Your ref: H04/0152/06
Our ref: 641 2 LMS VJA

24 July 2006

**GEORGE BARNSDALE AND SON
DEMOLITION OF STORE AND ERECTION OF A JOINERY PRIMING
WORKSHOP (NECESSITATING THE DIVERSION OF PUBLIC
FOOTPATH)
LAND OFF HIGH STREET, DONINGTON**

ELEVATION B

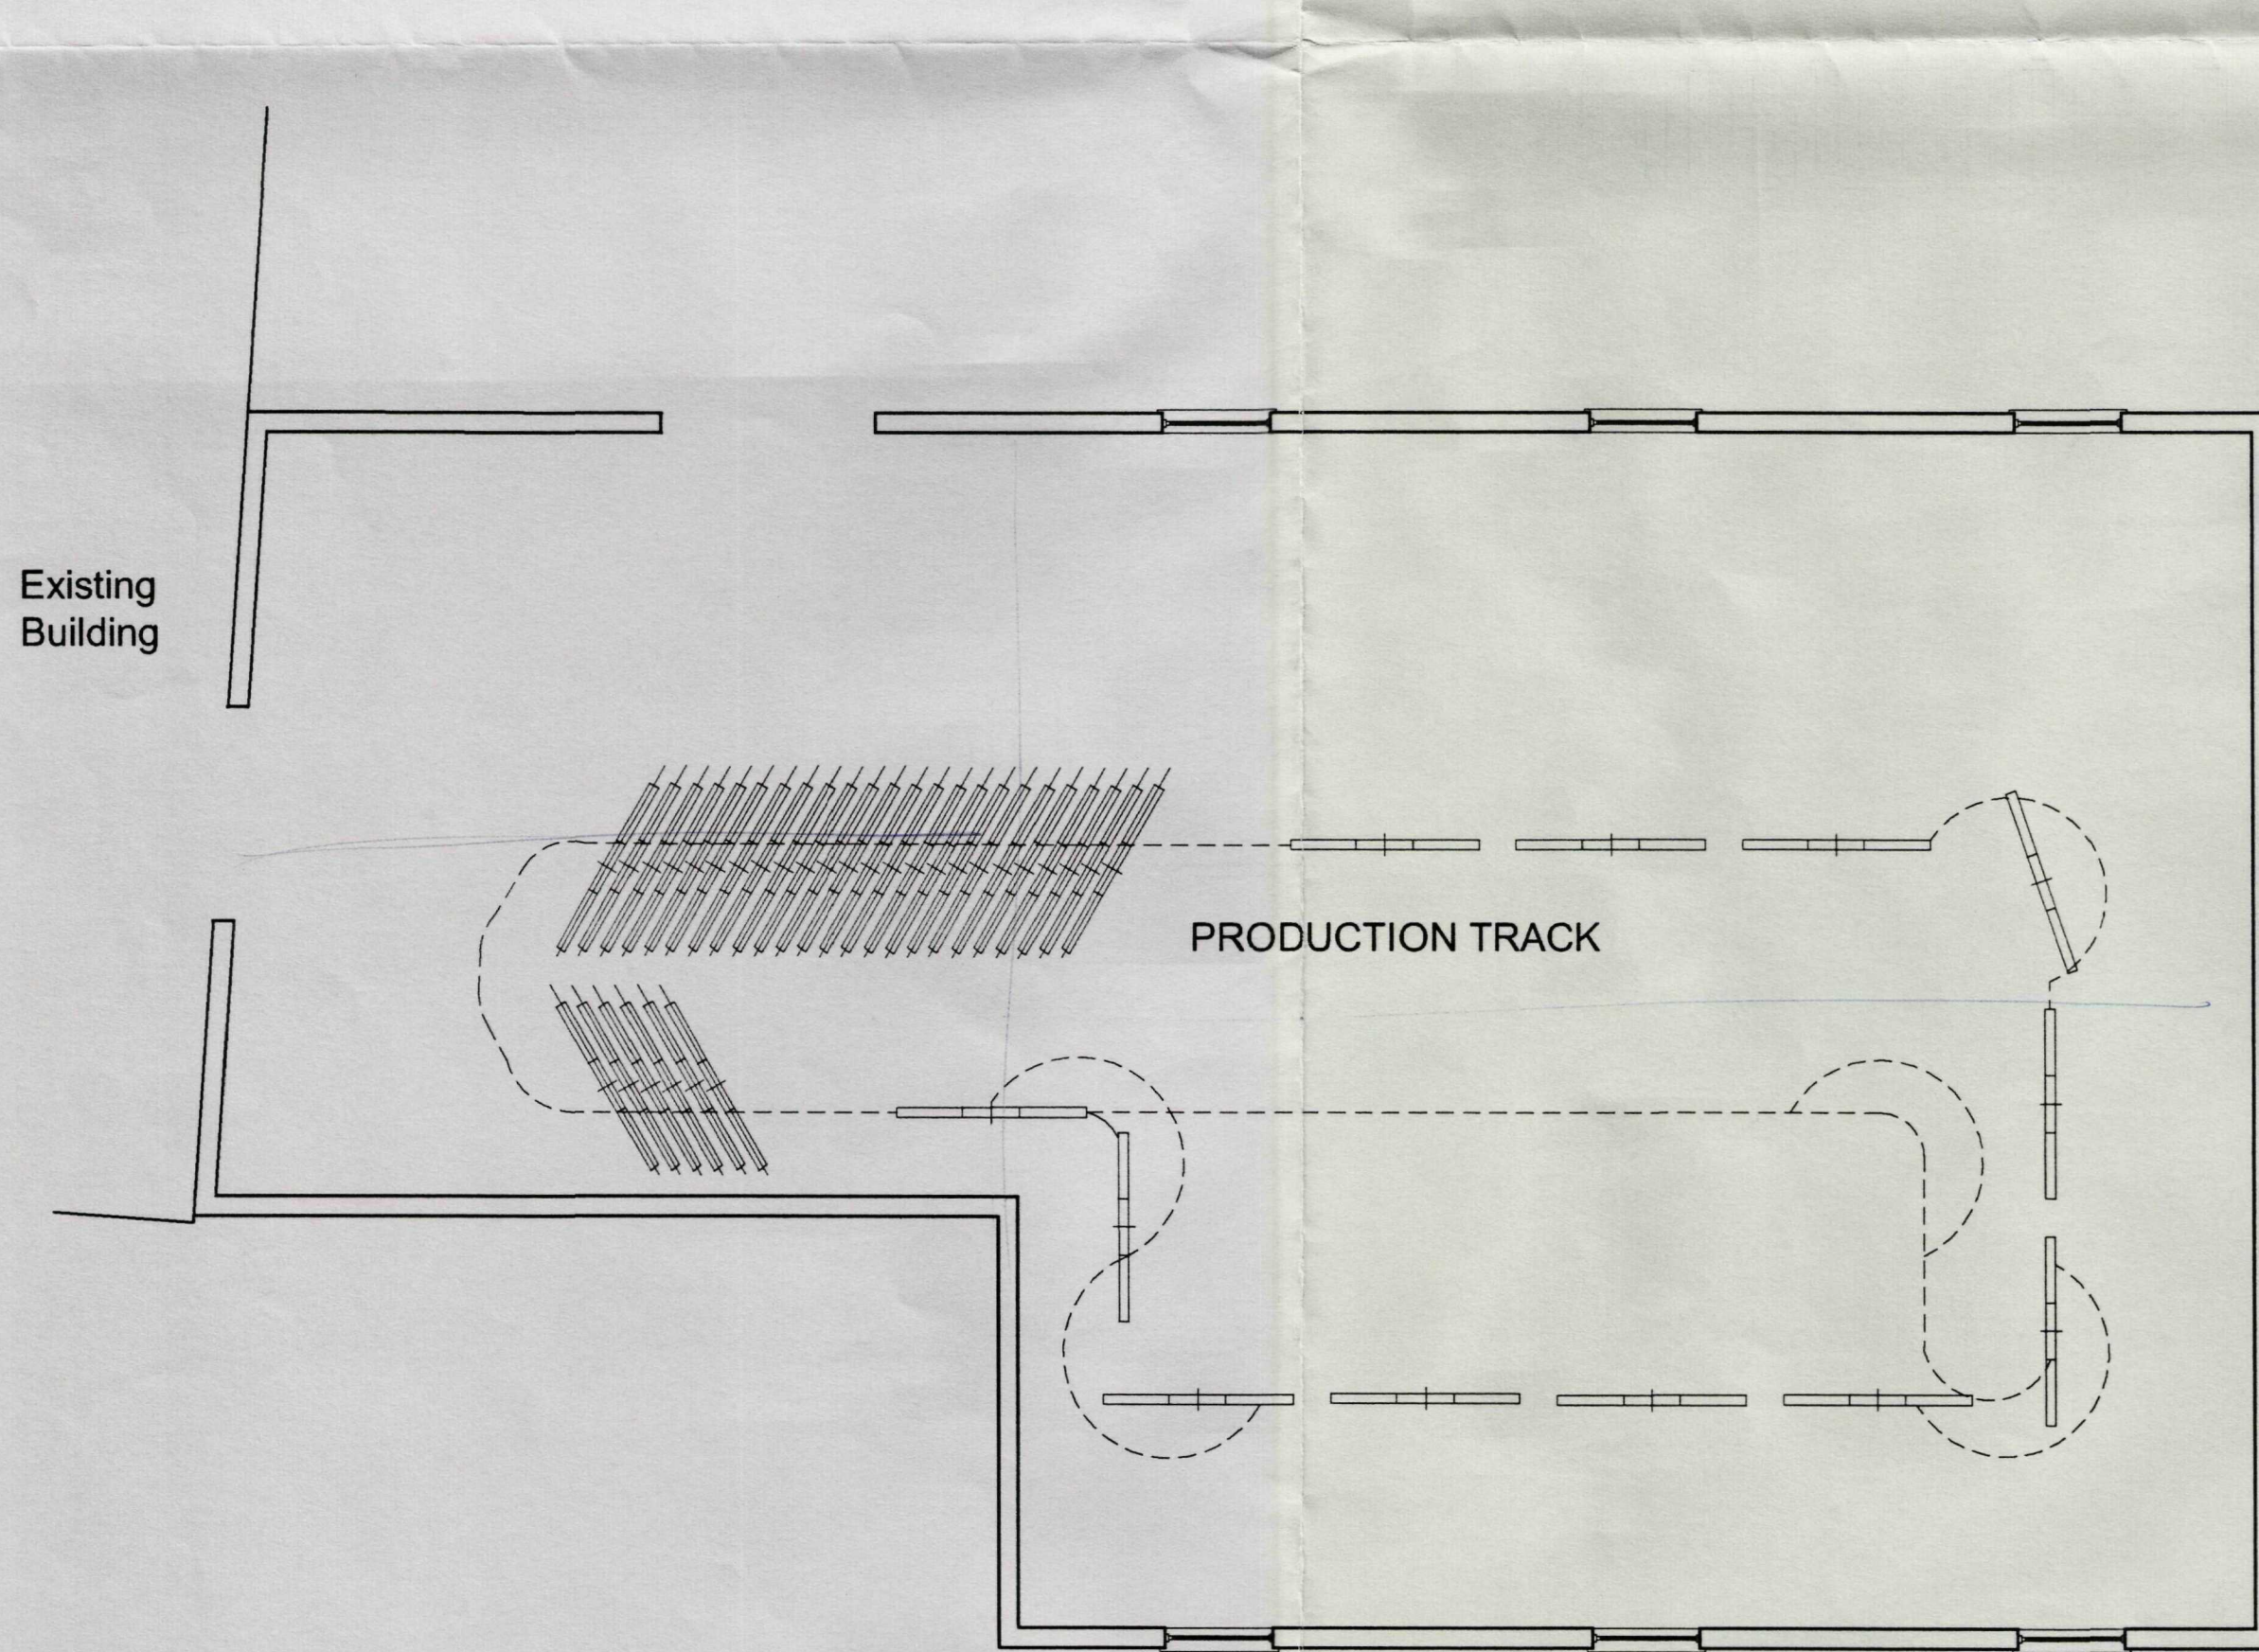
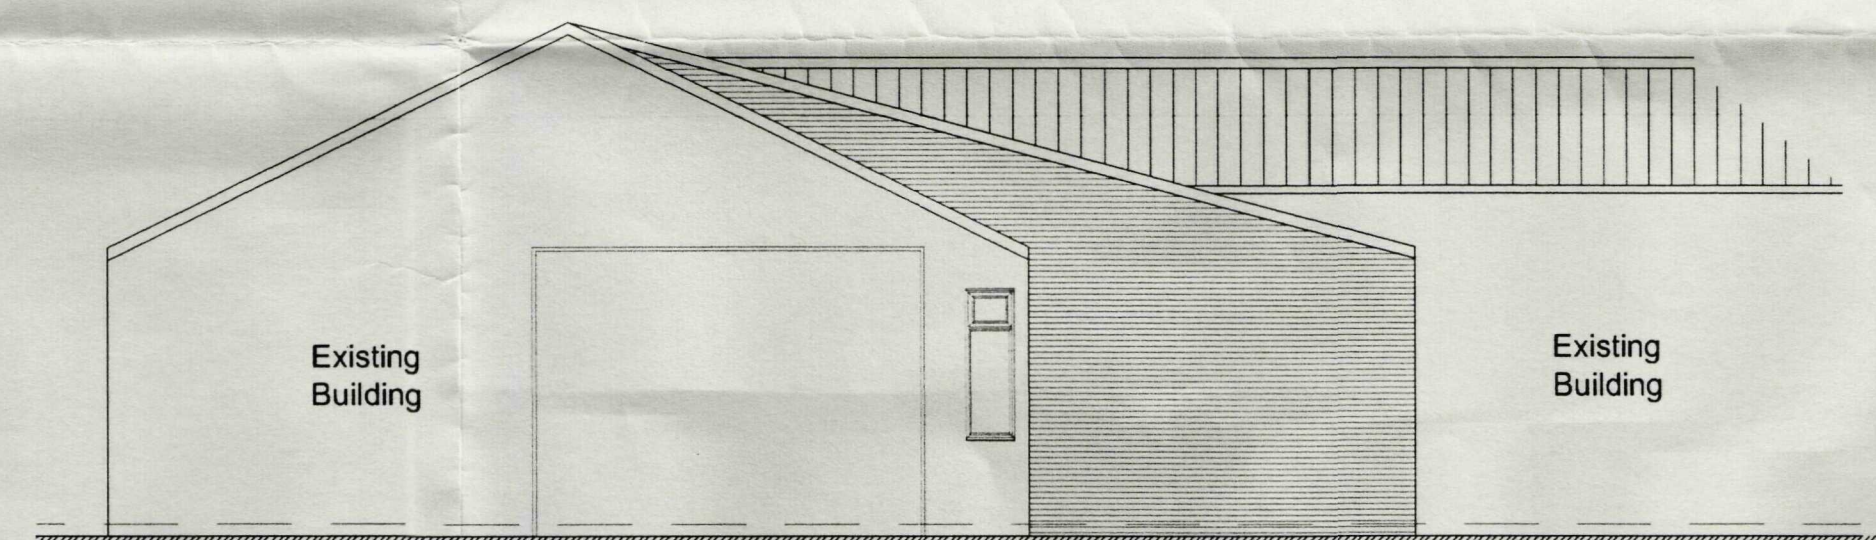
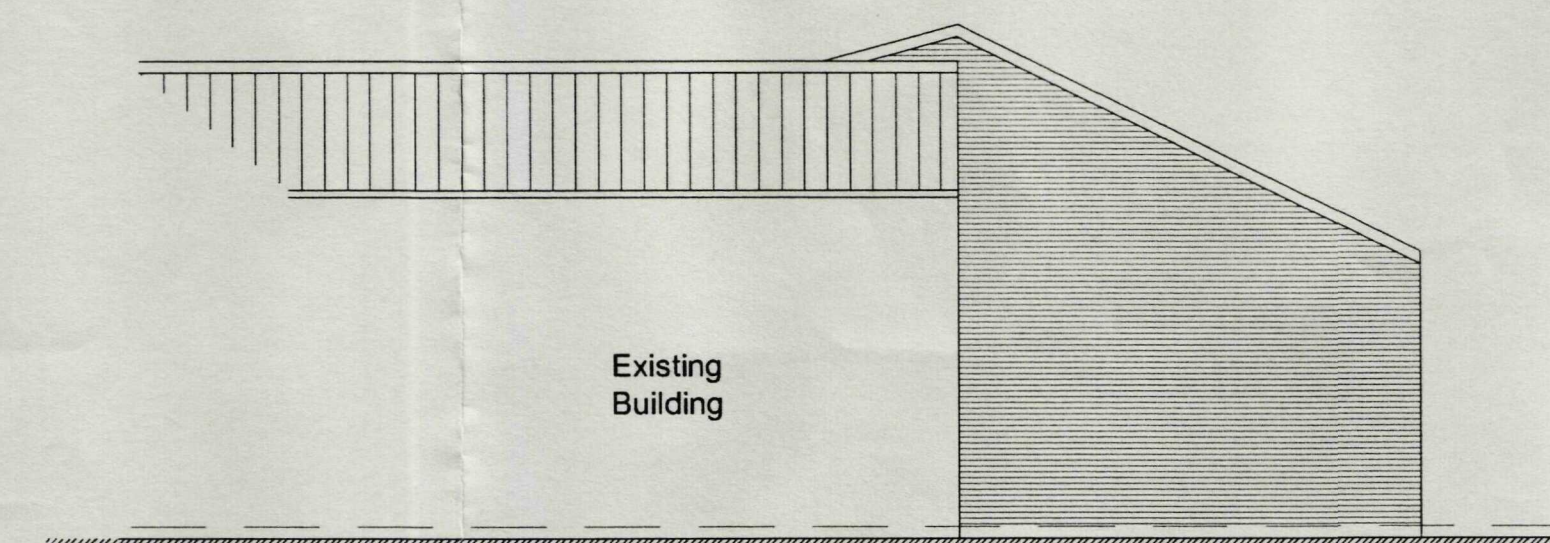
We have changed the roof pitch to reduce the amount of brickwork on the western elevation of the workshop that is visible from the Public Footpath. In addition, we have added some relief brickwork to break up the façade.
